Approval of details reserved by condition imposed under ref A/51/14/OUT relating to Condition Nos 4 - materials & finishes, 5 - retained trees, 6 - surface water drainage, 7 - car parking 9 - roads, footways & casual parking areas, 10 - Construction Management Plan, 11 - Travel Plan, 12 - archaeological, 13 - ecology, 14 - broadband, 19 - foul water sewerage disposal, 20 - public water supply, 21 - surface water drainage, 22 - SuDs, 23 - refuse & recycling bins, 24 - contamination, 29 - pedestrian & cycle linkages & vehicular access and 30 - materials & finishes

Manor Nursery High Street Angmering BN16 4AW

Arun District Council have decided to **REFUSE details reserved by condition for the following reasons:**

The information submitted regarding Condition 21 imposed on the outline planning permission A/51/14/OUT: relating to the full details of the proposed surface water drainage scheme is refused as insufficient information has been submitted to ensure the proposed development is satisfactorily drained.

TITLE
Proposed Drainage Strategy

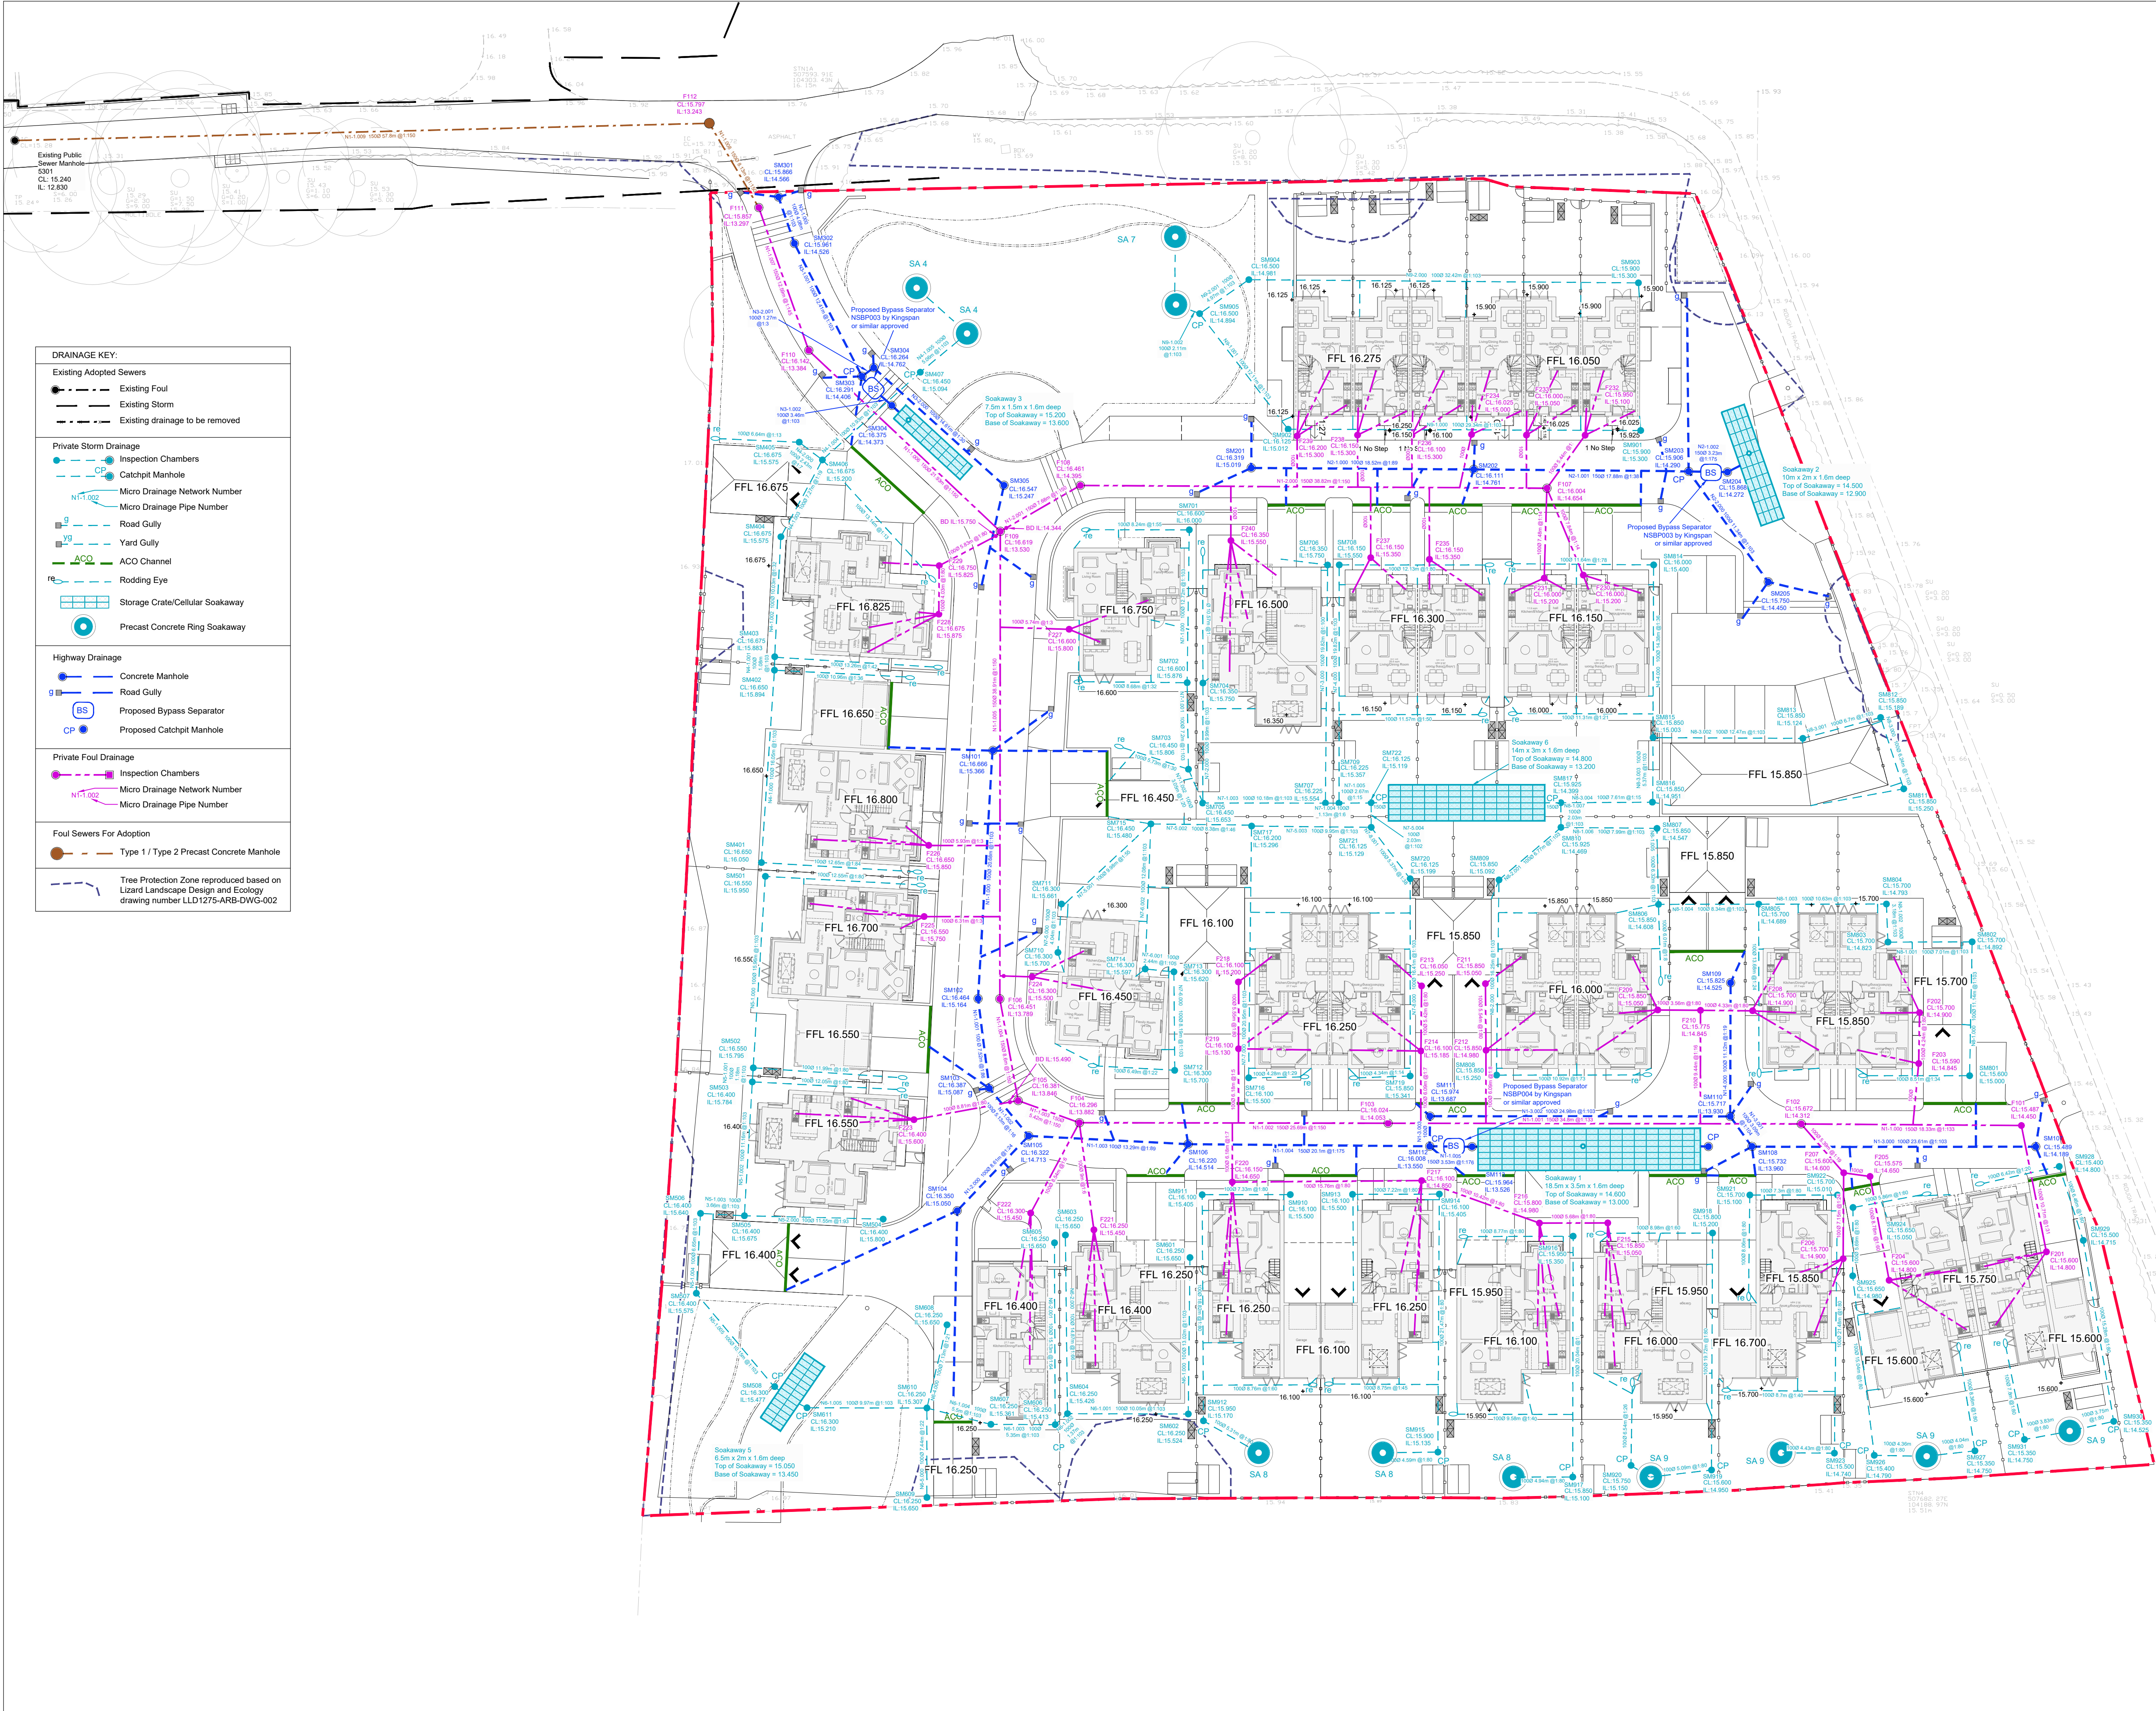
Ground water monitoring was undertaken at only two locations on site, and was not undertaken for the entire winter period as outlined in the condition. It is deemed that the level of data presented is insufficient.

Infiltration testing was undertaken in June. Winter infiltration testing must be undertaken. All infiltration tests were undertaken at circa 2.5 metre depth, yet some of the soakaways are considerably shallower than this.

Further winter groundwater monitoring and winter infiltration testing is required.

It is not possible to review the robustness of design without this information. Design must be evidenced to have surface water features above peak seasonal groundwater levels, and design must be based on winter infiltration rates to ensure it is able to cope with seasonably lower permeability. This is important to ensure flood risk is not increased as a result of development.
